The Coal
Authority

Re: 2025/0149

Change of use of land to a gypsy/traveller site including erection of a day room; hardstanding and boundary treatments (Retrospective); Hill Top Park, Land Off Wakefield Road, Smithies, Barnsley, S71 1ND

The Coal Authority response: **Fundamental Concern (Layout)**

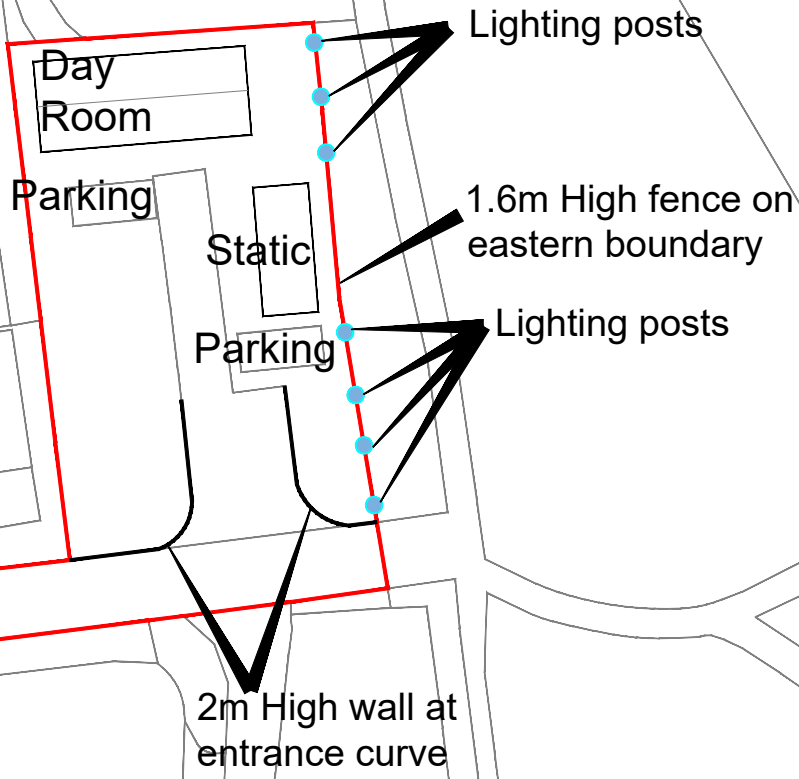
and therefore the layout is to be determined, we have concerns, specifically the siting of the day room. In accordance with Drawing No BAWA 001 – Proposed Site Plan the day room is over and / or within influencing distance of all mine entries affecting the site. This layout does not accord with our adopted policy (above).

Accordingly, the Coal Authority **objects** to this planning application as a result of the **significant layout implications presented by the recorded mine entries**. We consider that the applicant has failed to demonstrate to the LPA that the application site can safely accommodate the proposed development.

The applicant should be advised that the recommended intrusive site investigations should be undertaken to locate and determine the condition of the recorded mine entries within the site boundary. Zones of influence should be calculated for these features and any off-site mine entry within influencing distance of the site and the zones should be considered as no build exclusion zones. These no build exclusion zones should then inform the site layout; predominantly the siting of permanent structures. We would expect that these works are undertaken prior to determination and a report of the findings along with a layout plan plotting the found location of these features and their no-build exclusion zones should be submitted for consideration along with any remedial and mitigatory measures proposed.

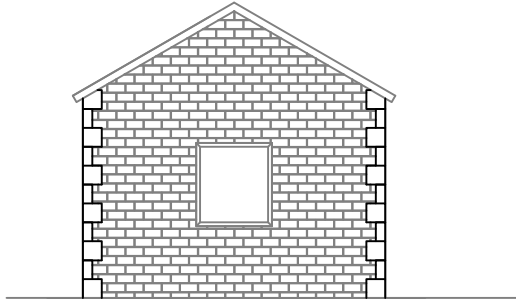
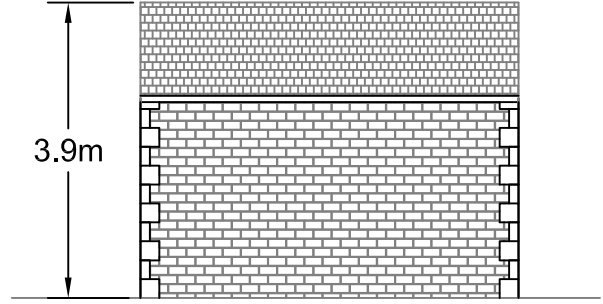
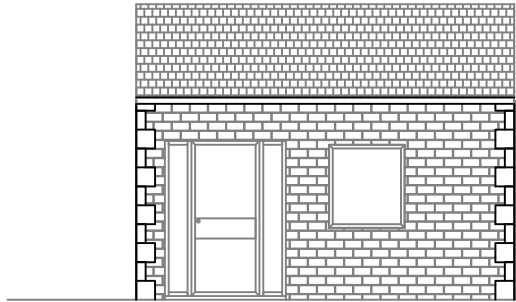
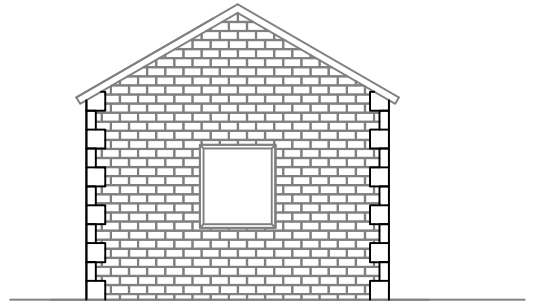
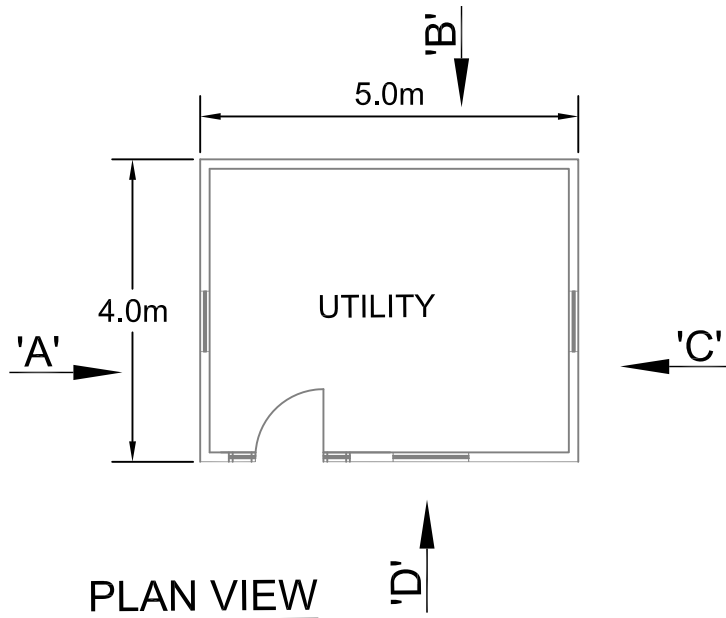
<https://www.gov.uk/government/publications/building-on-or-within-the-influencing-distance-of-mine-entries> Based on the limited information known for these recorded mine entries, the entire site lies within influencing distance of these features. Therefore it is currently unclear if the permanent building (day room) can be built outside the zone of influence of these features in line with our adopted policy.
